SUBJECT: Engineering Review Comment
Mountain View Electric Association Inc. (MVEA)

Project Name: Iron Ridge Final Plat Filing No. 2

Project Number: SF2612

Description: Proposed development of 14 residential lots located at Walker Rd and Stepler Rd in Township 11S, Range 66W, Section 13.

FINAL PLAT
IRON RIDGE FILING NO. 2

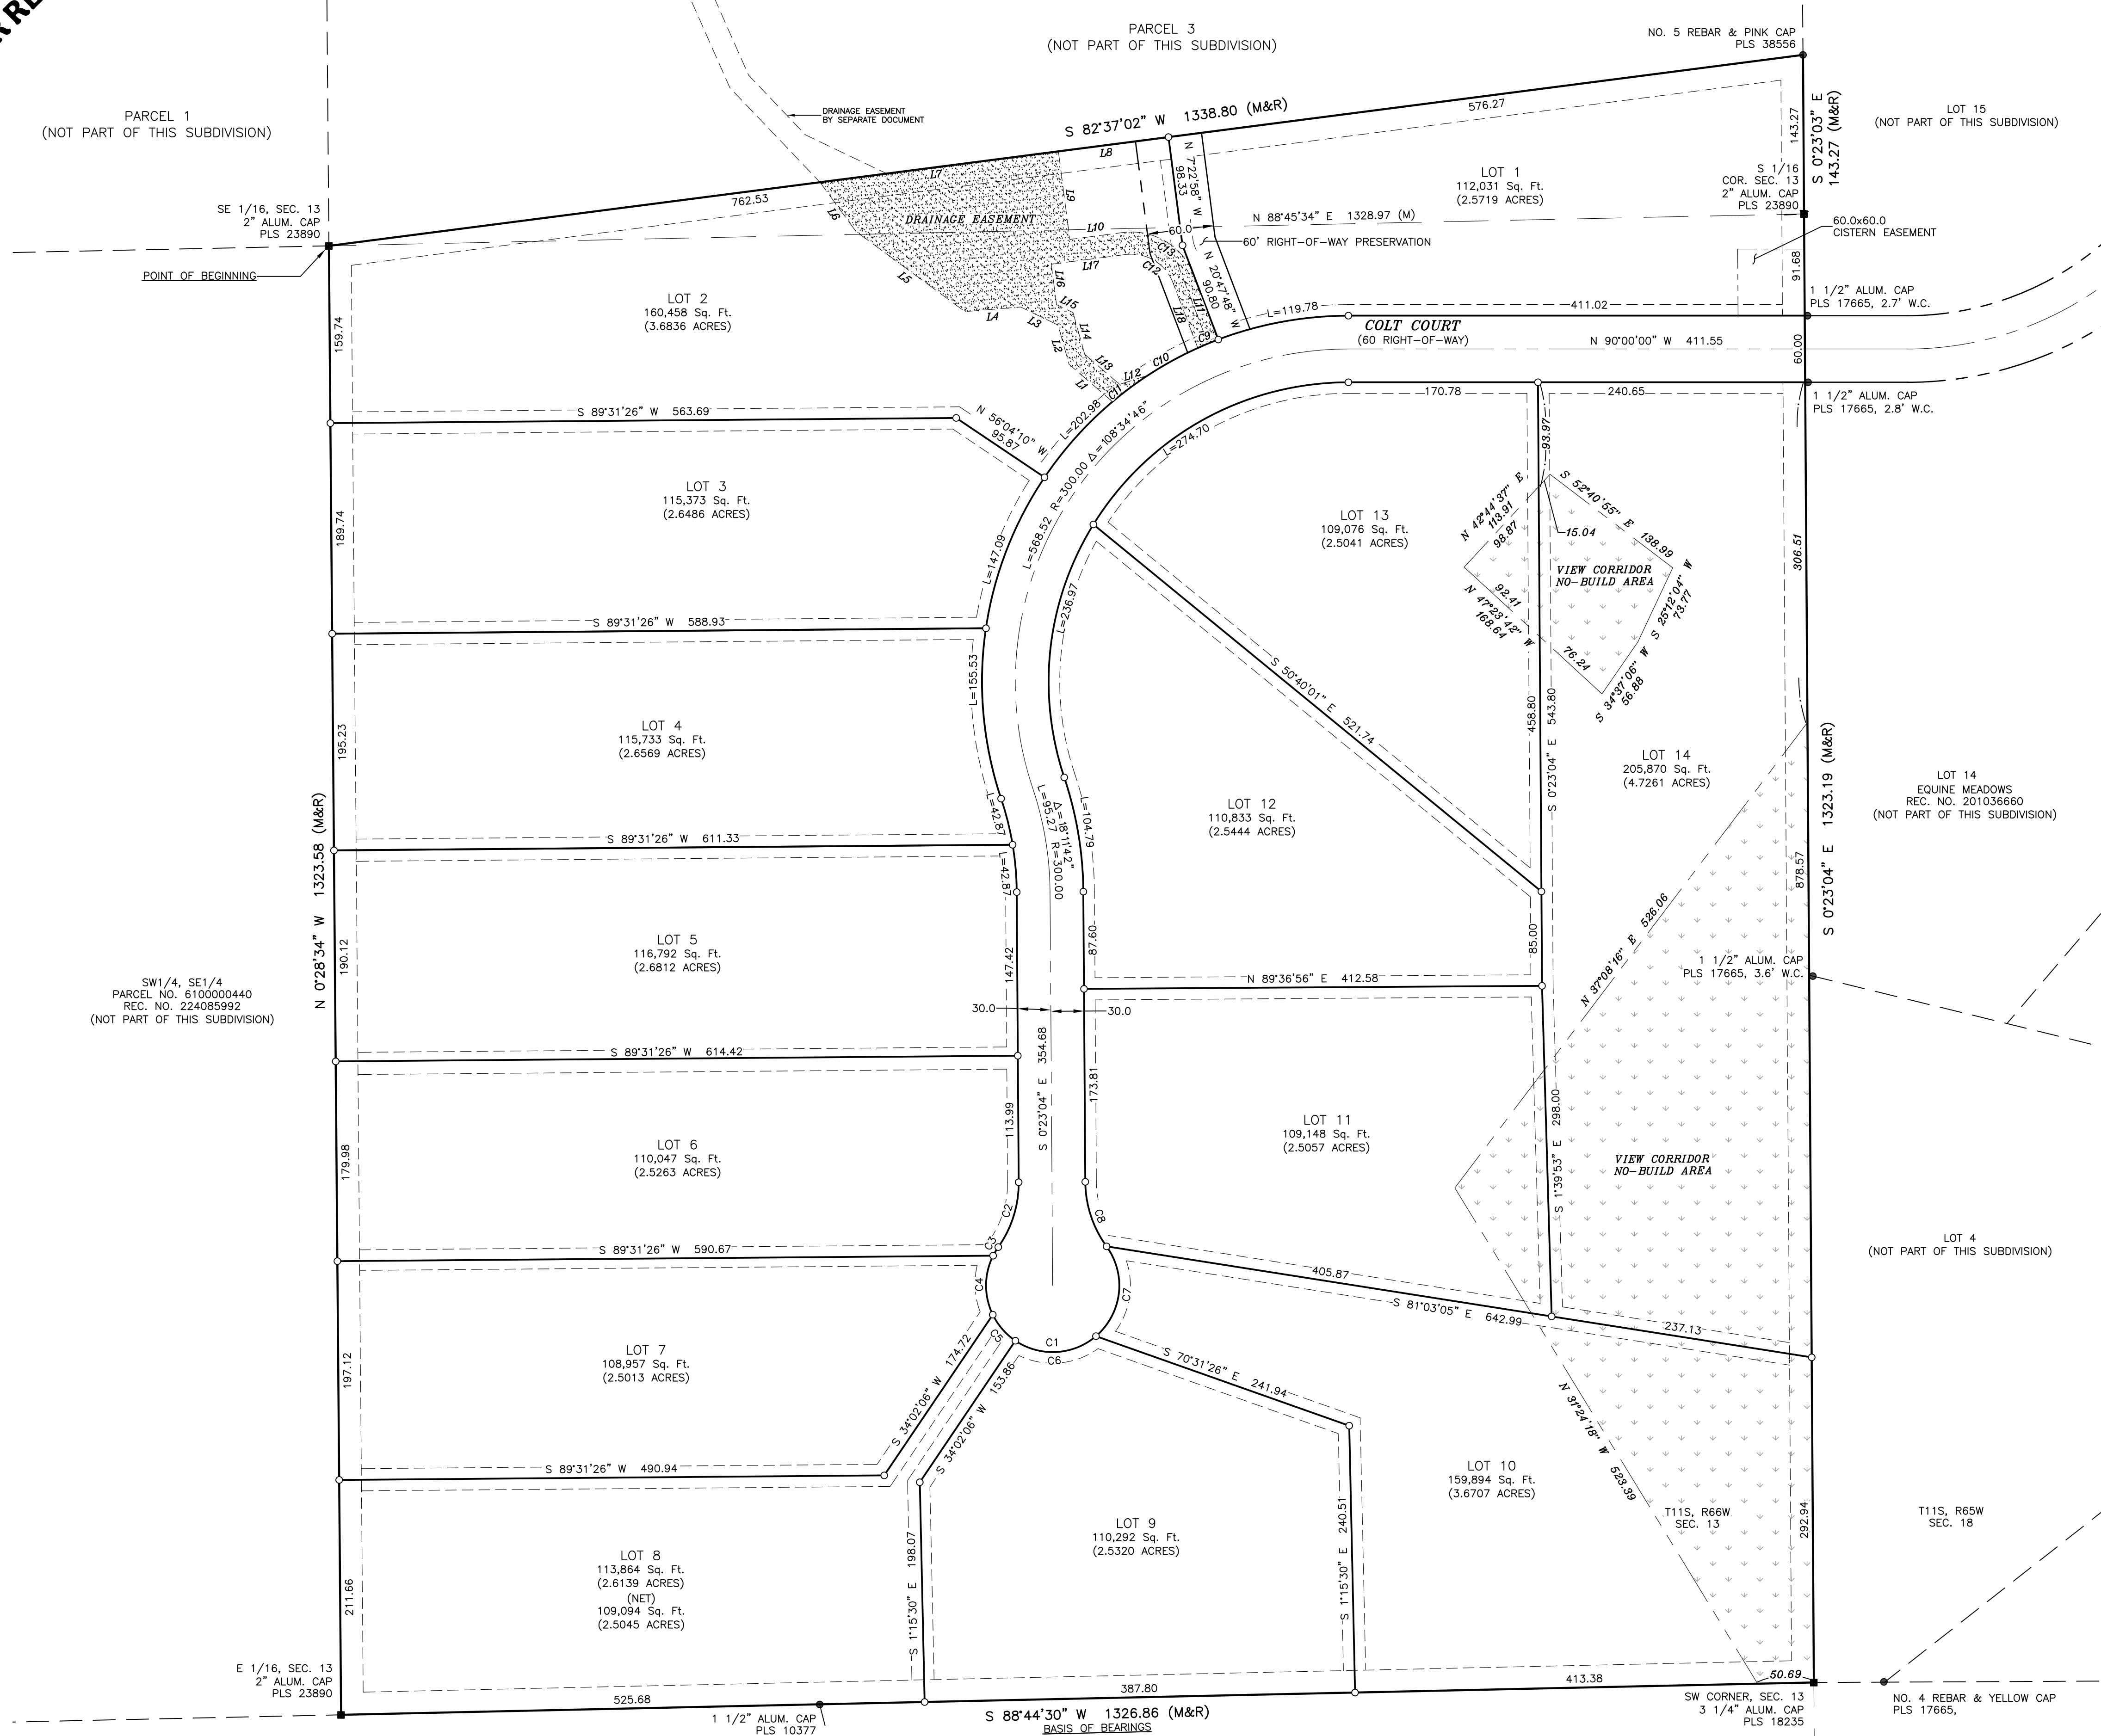
MVEA requests a ten (10) foot front, side, and rear lot utility easement and all tracts, along with a twenty (20) foot exterior utility easement on the plat. MVEA also requests the platting of MVEA's existing facilities with easements on the plat. Additional easements may be required.
